RE: APPLICATION BY HIGHWAYS ENGLAND FOR AN ORDER GRANTING DEVELOPMENT CONSENT FOR THE A14 HUNTINGDON TO CAMBRIDGE IMPROVEMENT SCHEME

SUMMARY OF REPRESENTATION FROM THE UNIVERSITY OF CAMBRIDGE

This is a record of the representation made by John Hopkins from Peter Brett Associates LLP at the Open Floor Hearing on July 14th 2015.

Drawing title: **LAND PLANS REGULATION 5(2)(i) SHEET 23 OF 40**

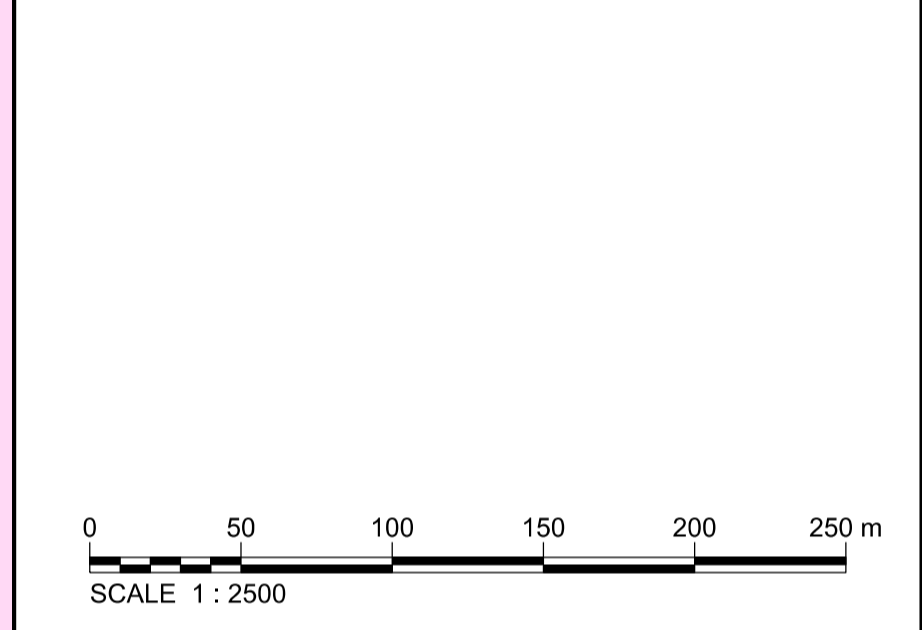
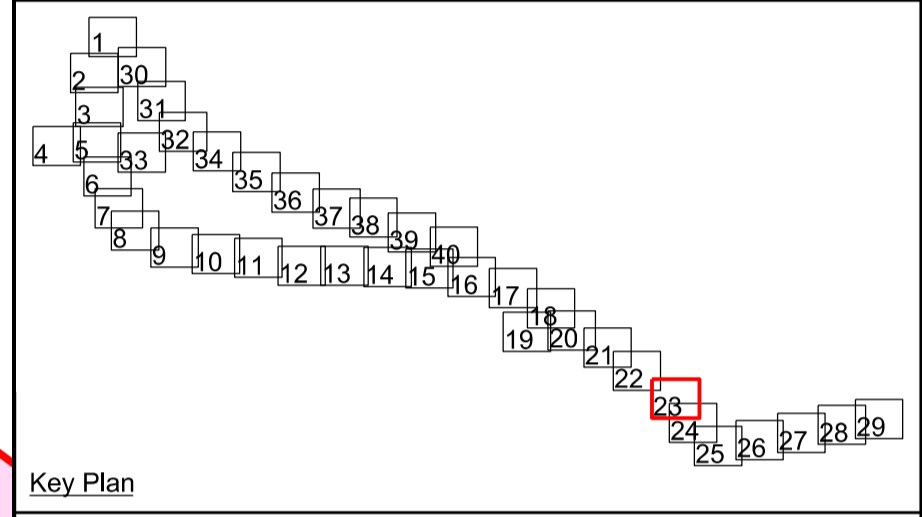
11. Four attenuation ponds are shown as being outside of the limits of land to be acquired within Ladysmith Farm and the St. John's Land on the Rights of Way & Access Plans Regulations 5(2)(k) & 5(2)(o) Sheet 23. As these are operational facilities serving the drainage function of the A14 trunk road, the University does not accept that these should be within its ownership, and seeks that the limits of land to be acquired should be amended accordingly (page 13, Sheet 212).

Drawing title: **CROWN LAND PLANS REGULATION 5(2)(n) SHEET 19 OF 32**

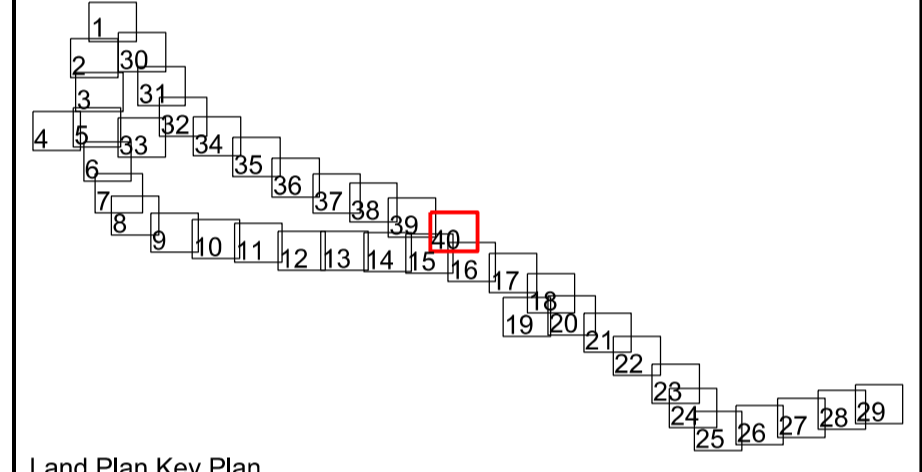
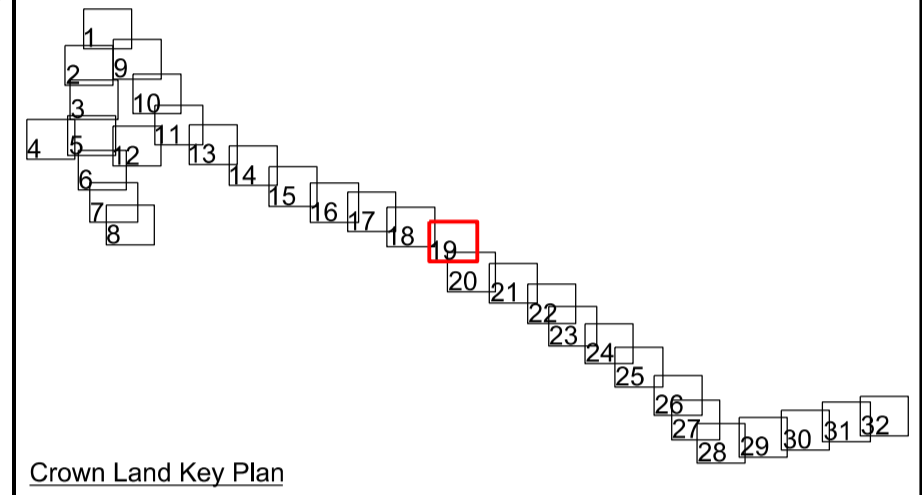
- 5. Two attenuation ponds are shown as being outside of the trunk road boundary within Yarmouth Farm on the Rights of Way & Access Plans Regulations 5(2)(k) & 5(2)(o) Sheet 19. As these are operational facilities serving the drainage function of the A14 trunk road, the University does not accept that these should be within its ownership, and therefore seeks that the limits of land to be acquired should be amended accordingly (page 5, Sheet 162).
- 6. The University seeks that the existing direct access routes from the A14 to Yarmouth Farm be maintained (page 4, Sheet 162).

- 7. An attenuation pond is shown as being outside of the limits of land to be acquired within Grange Farm on the Rights of Way & Access Plans Regulations 5(2)(k) & 5(2)(o) Sheet 19. As this is an operational facility serving the drainage function of the A14 trunk road, the University does not accept that it should be within its ownership, and seeks that the trunk road boundary should be amended accordingly (page 6, Sheet 162).
